CITY OF ALBUQUERQUE

March 9, 2018

RE: **417 Headingly Ave, N.E**
Grading Plan
Engineer's Stamp Date 3/6/18
Hydrology File: G14D090

Based on the information provided in your submittal received 3/7/18, the Grading Plan cannot be approved until the following are addressed:

**417 HEADINGLY AVE., NW
GRADING PLAN**

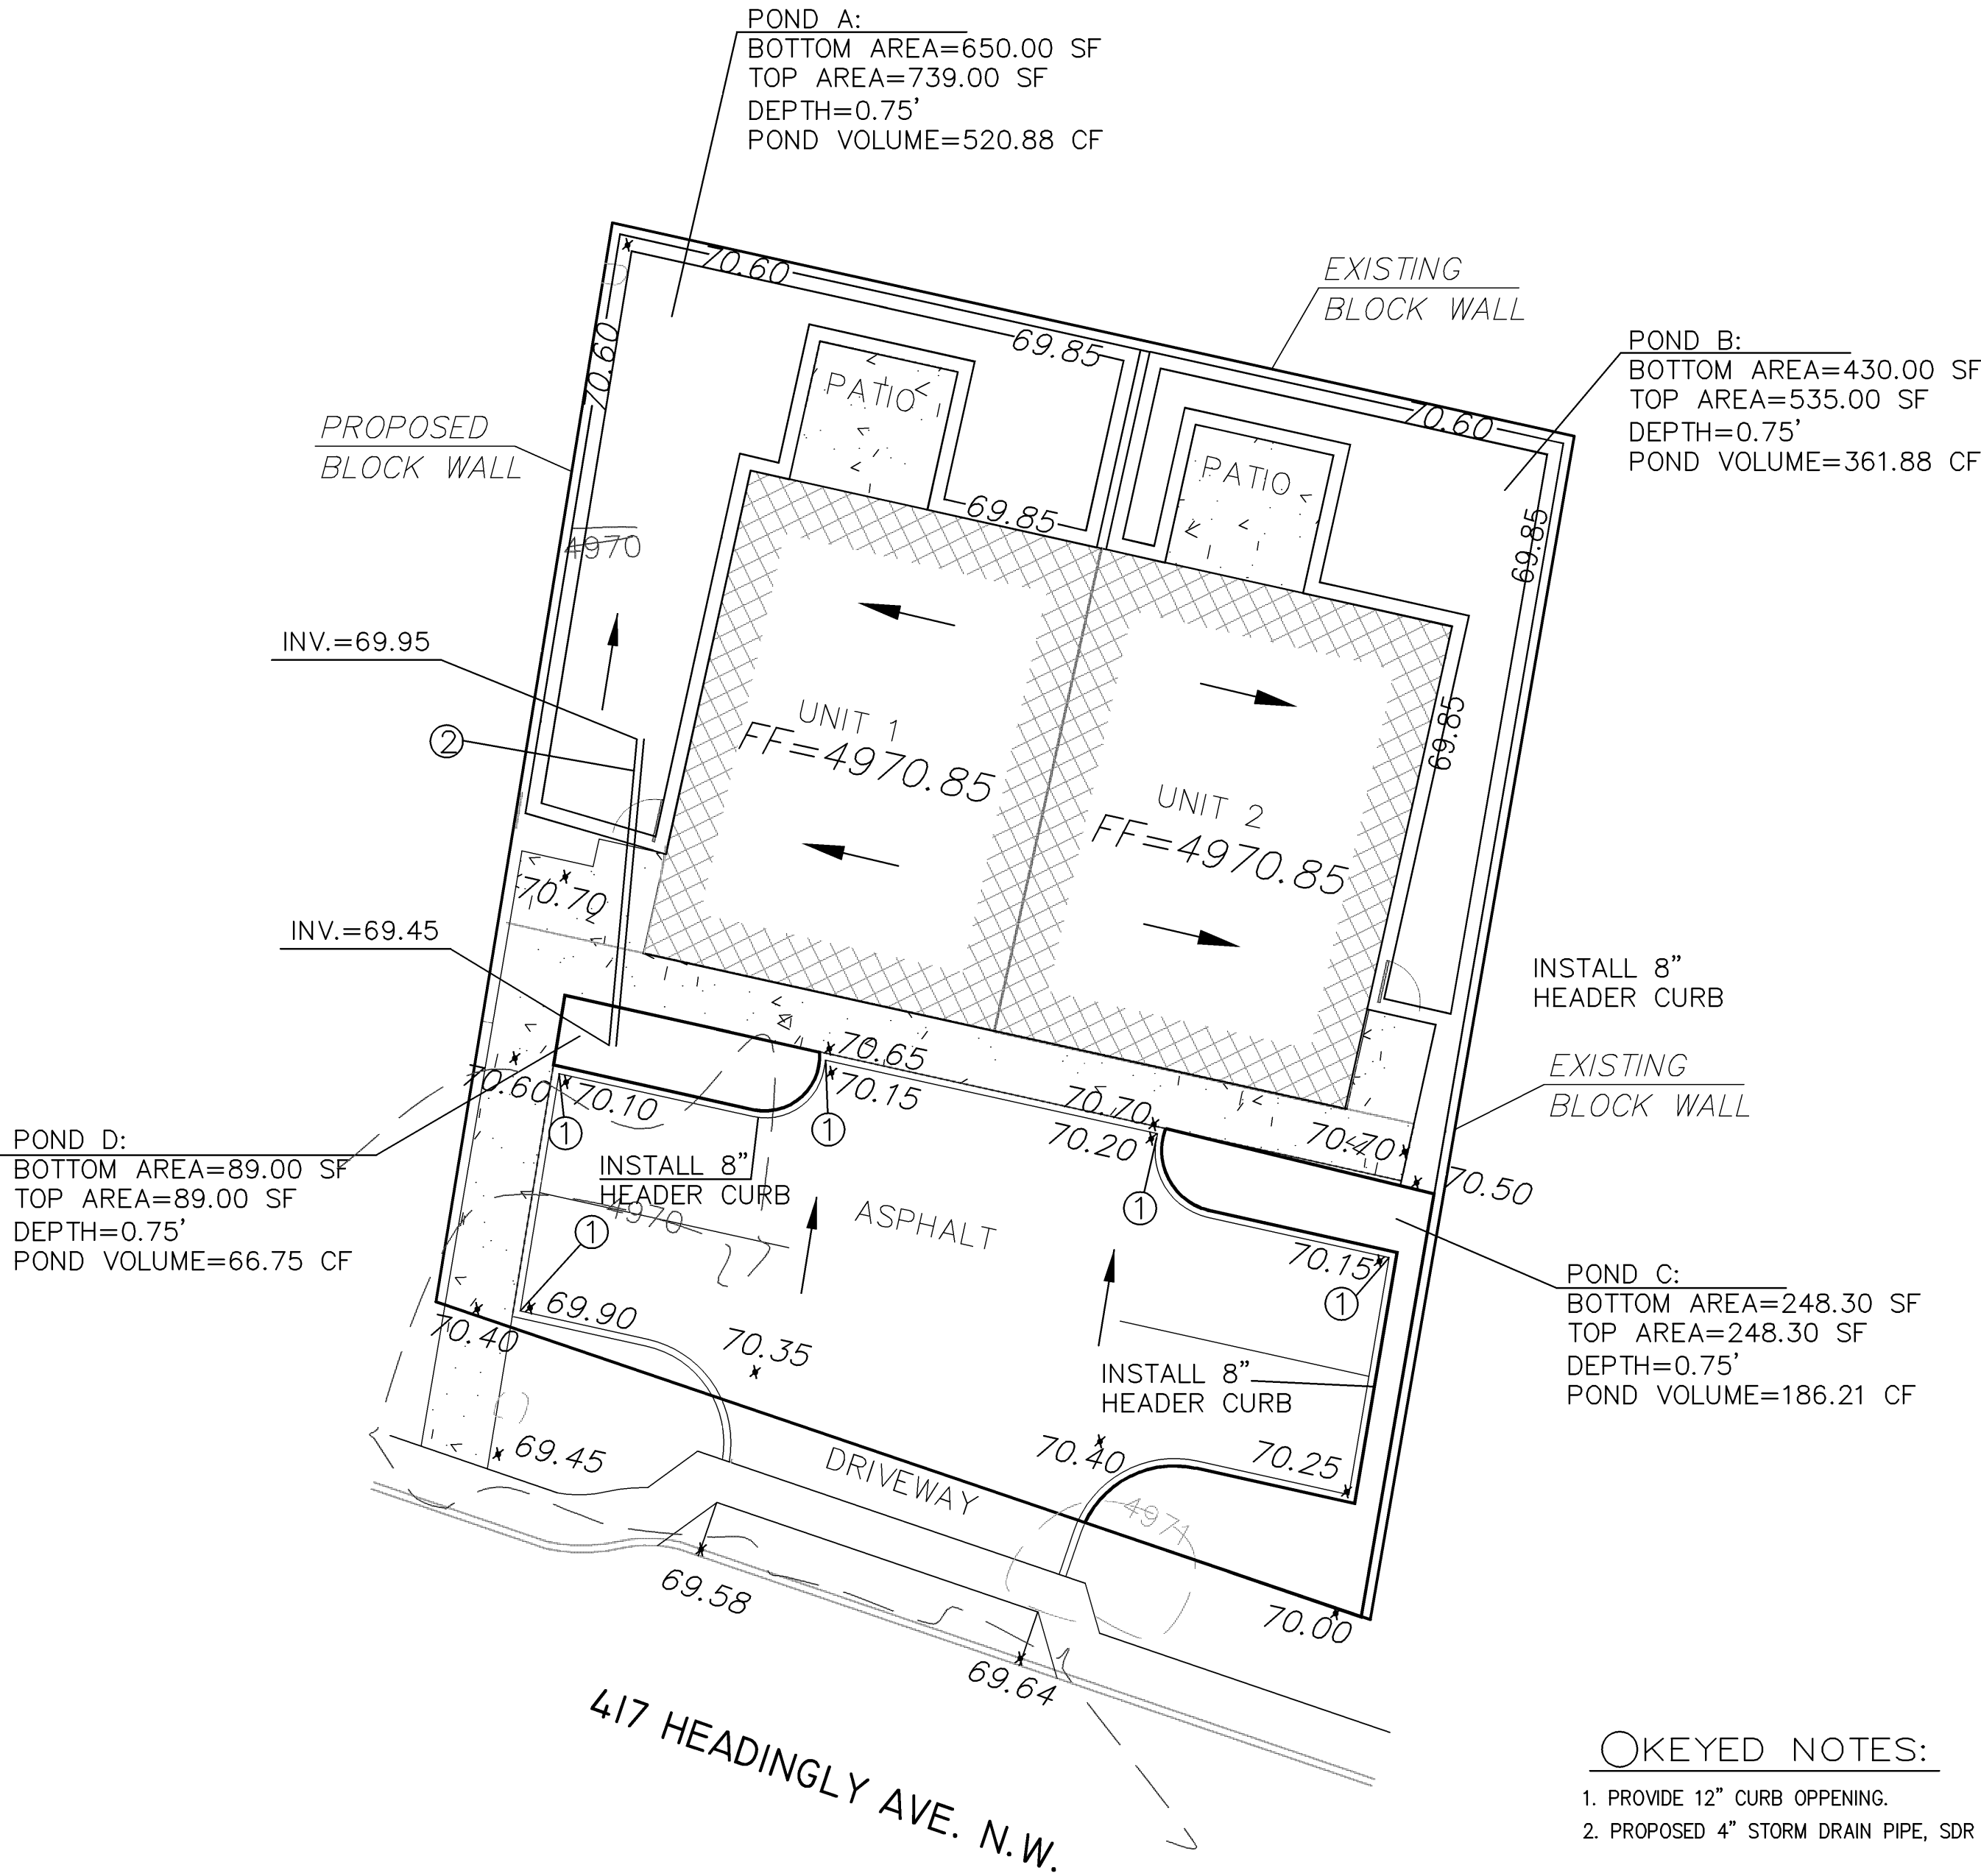
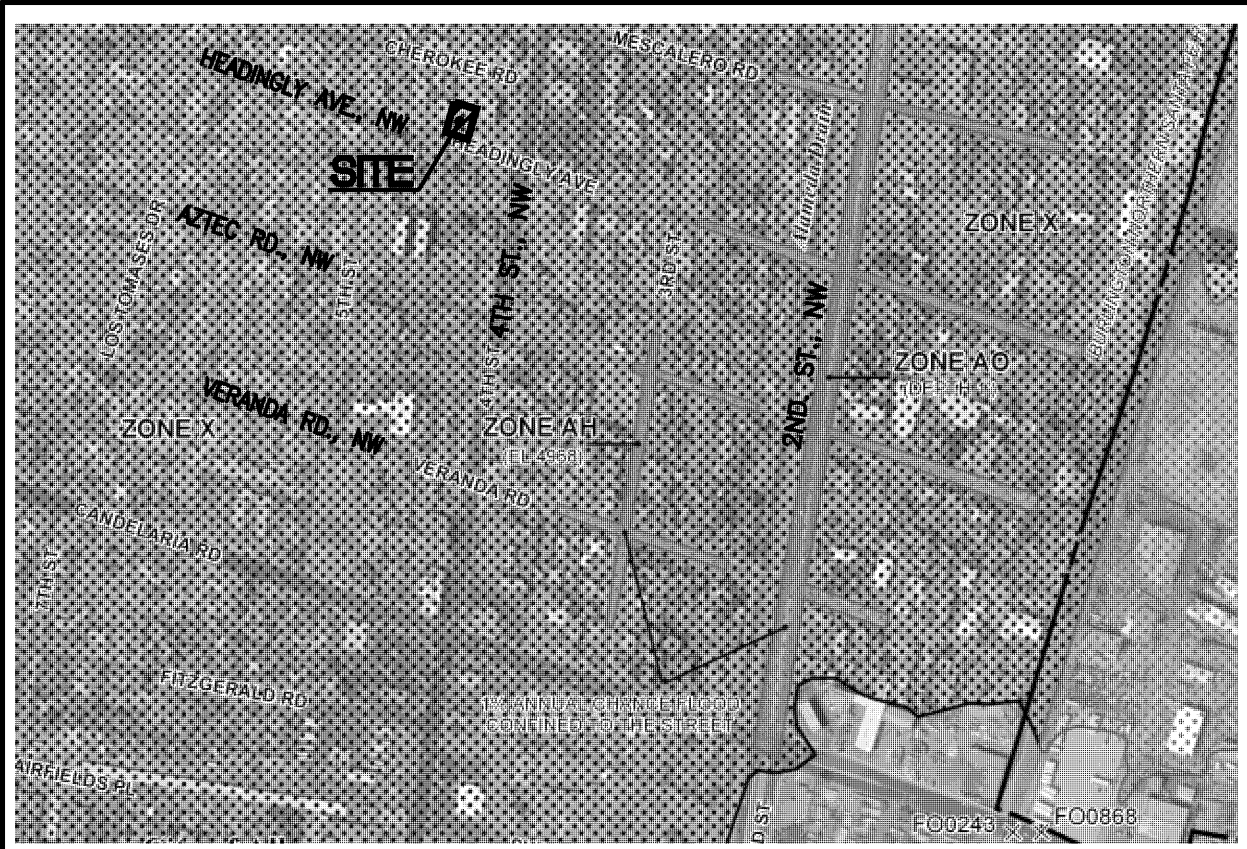
1. The site must demonstrate adequate downstream capacity per § 14-5-2-12(G) of the Albuquerque Code of Ordinances prior to authorizing any increase in runoff.
2. If downstream capacity cannot be demonstrated, onsite ponding of the increased runoff will be required.
3. It is recommended that the finished floor elevations be elevated at least 1 foot above the overflow to the street.
